From: Sue Howell <Sue.Howell@arun.gov.uk>
Sent: 21 December 2021 16:03
To: Planning.Responses <Planning.Responses@arun.gov.uk>
Cc: Anita Gardner <Anita.Gardner@arun.gov.uk>
Subject: FW: Planning Consultation on: F/22/21/PL

Response to Planning Application

Application ref: F/22/21/PL

Location: Land rear of Paynters Croft Burndell Road Yapton BN18 0HR

Figure 5. Features to enhance / mitigate for impacts to bats designed into the scheme.

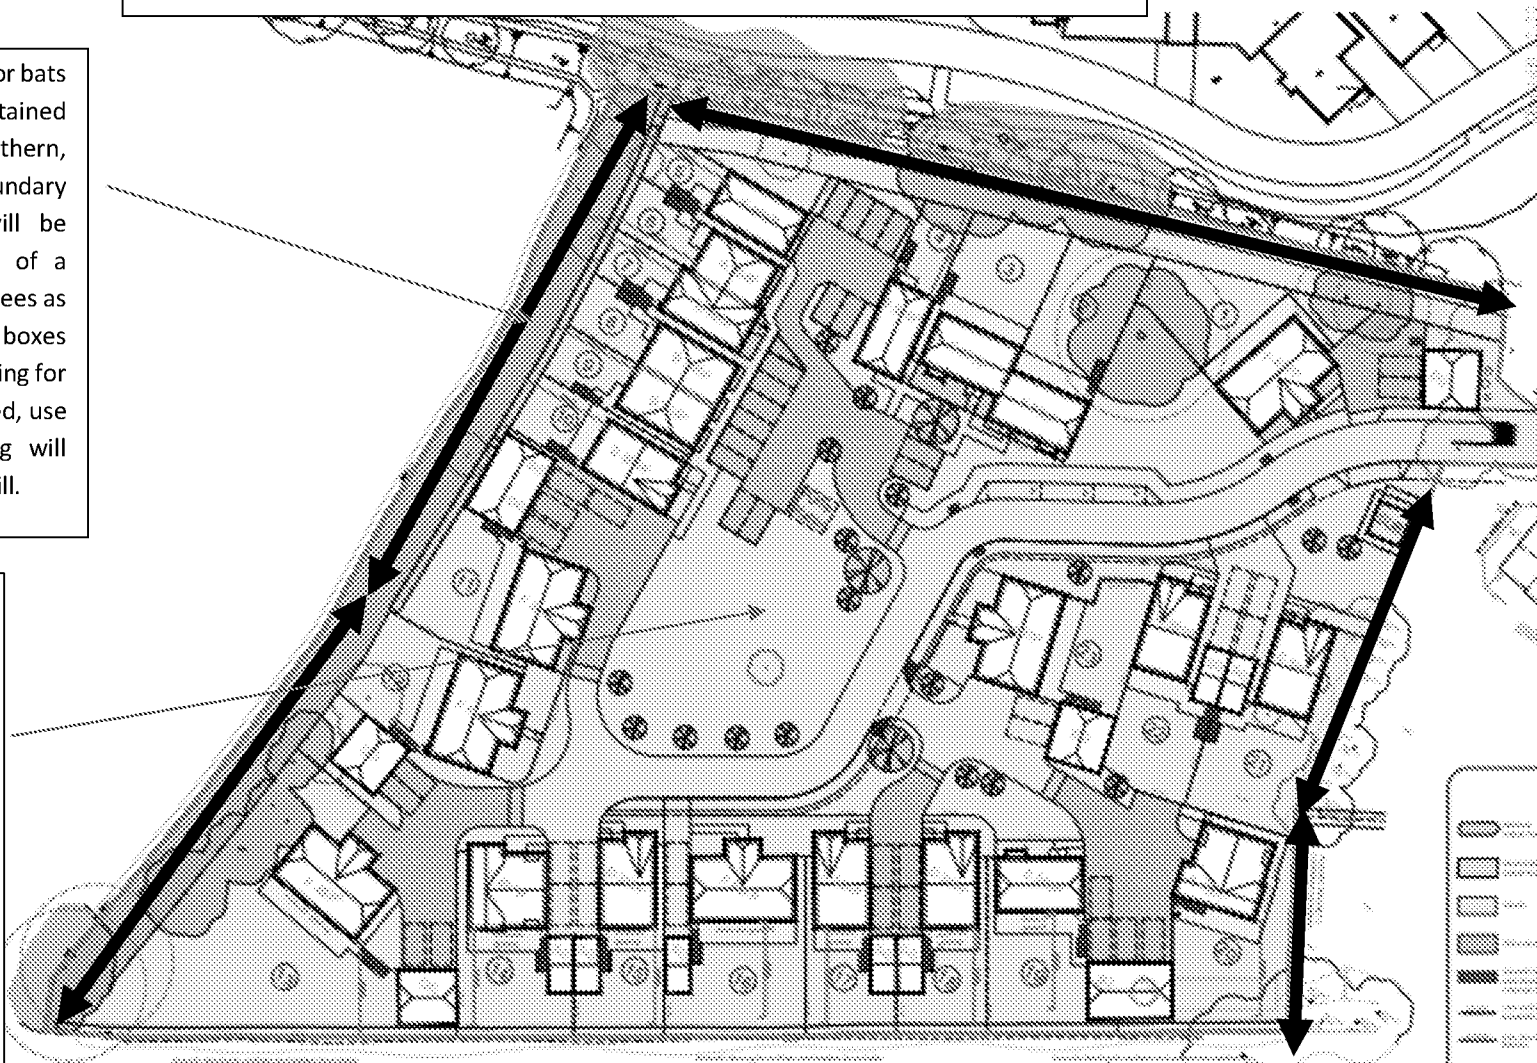
The indicated layout has proposed a central green area which is good to see with properties facing onto this open area. The Landscape Strategy Plan and Statement 03 A has shown indicative landscape proposals, however this would require further detail and specification in plan form. Confirmation of quantum of POS being provided will need to be provided.

The indicated layout would appear to show that trees on the northern and western edge are to be incorporated into a landscape buffer zone that should perpetuate the existing wildlife corridor within and beyond the site. It should be noted that existing trees and hedges contribute greatly to the character of the area and their future growth and influence should be a major consideration of the site layout.
